KITTITAS COUNTY COMMUNITY DEVELOPMENT SERVICES

RE: Homestead View Boundary Line Adjustment, BL-14-00009

Re: Homestead View (BL-14-00009)

TO: Kaycee Hathaway, CDS
FROM: Christina Wollman, Planner III *W*
DATE: April 25, 2014
SUBJECT: Homestead View BL-14-00009

EXHIBIT  
 BOUNDARY LINE ADJUSTMENT  
 HOMESTEAD VIEW PLAT  
 LOTS C3 & C4

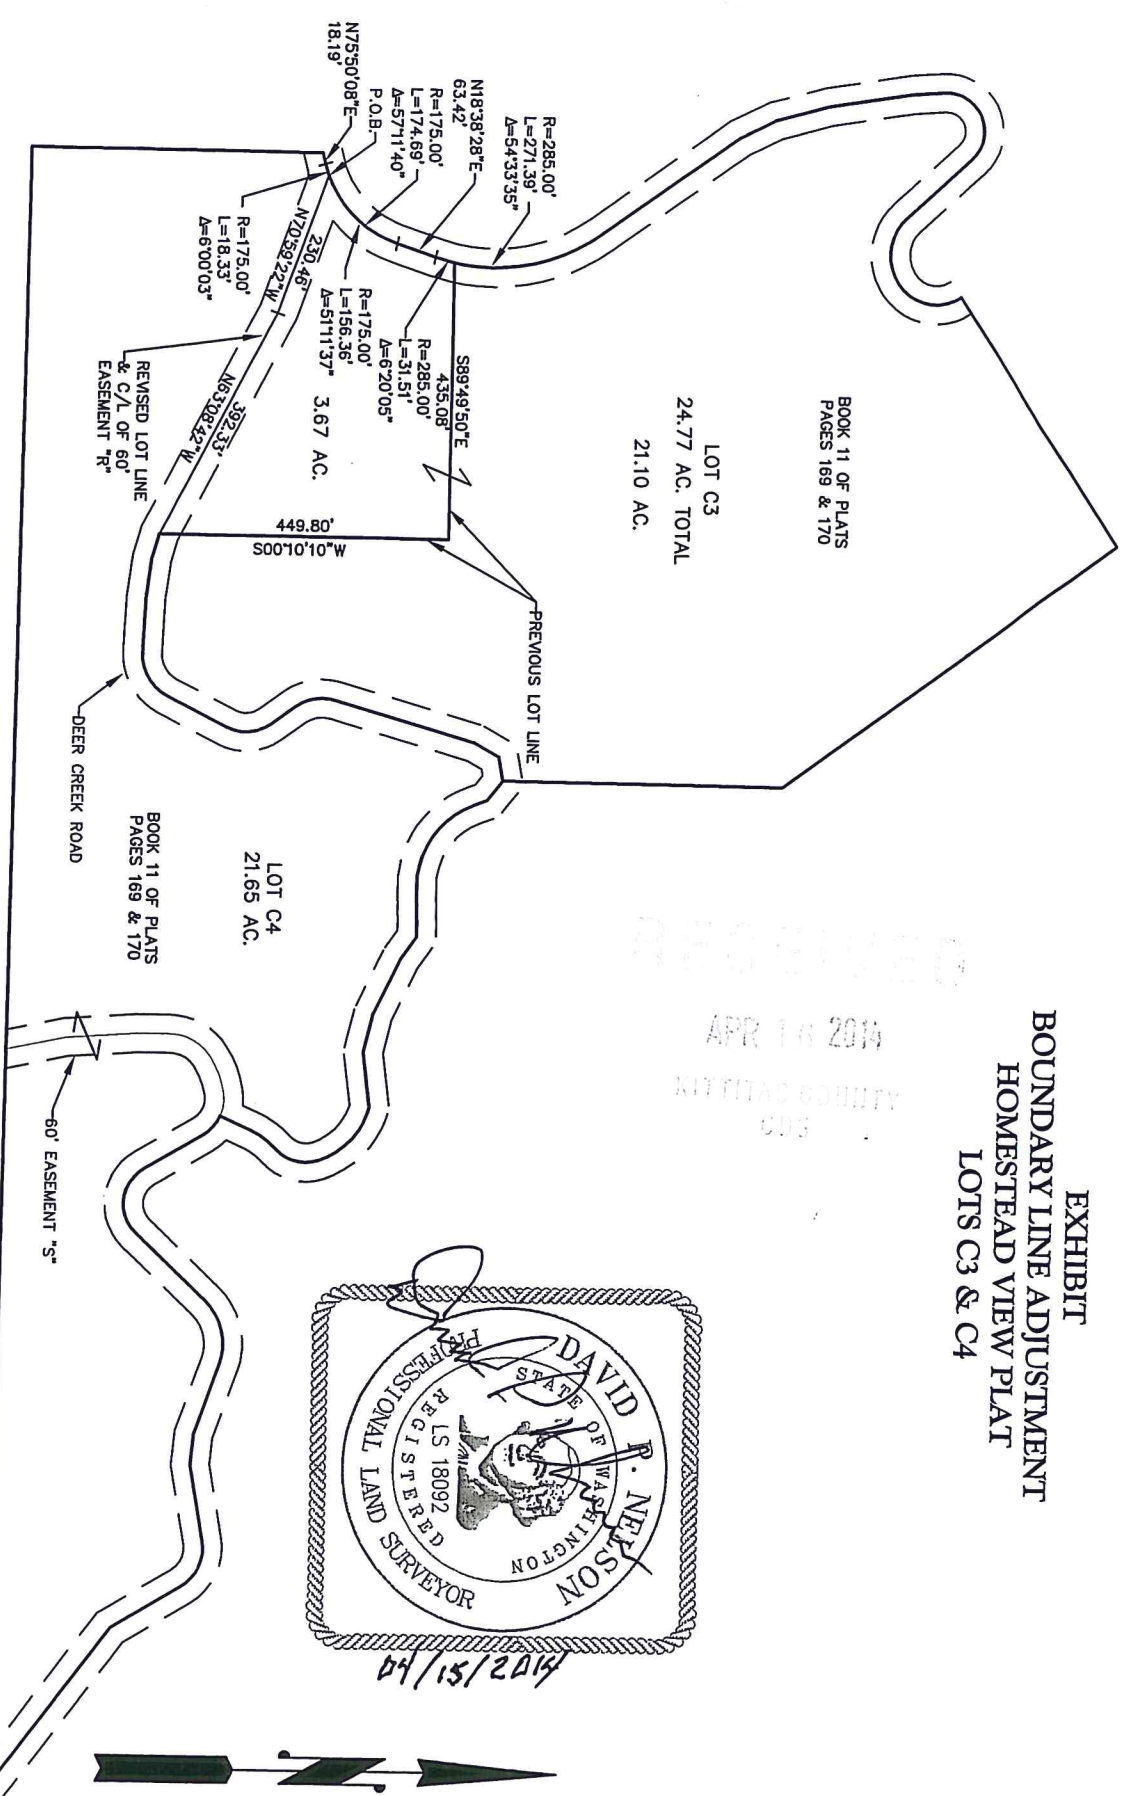
1. A legal description or survey displaying the new acreage and lot dimensions of each parcel must be submitted to our office prior to final approval.
2. Full year's taxes need to be paid for all tax parcel numbers per requirement of the Kittitas County Treasurer's Office.
3. Please refer to the attached Kittitas County Public Works and Kittitas County Fire Marshall Comment Memos for information regarding additional requirements.

- Ensure that boundary line adjustments do not infringe upon existing structures, to include propane tanks, etc.
- Ensure adequate access for fire apparatus. Any driveways or access points created based off the new lot configurations shall comply with Kittitas County Code 20.02.030.
- All future development must comply with the International Fire Code.
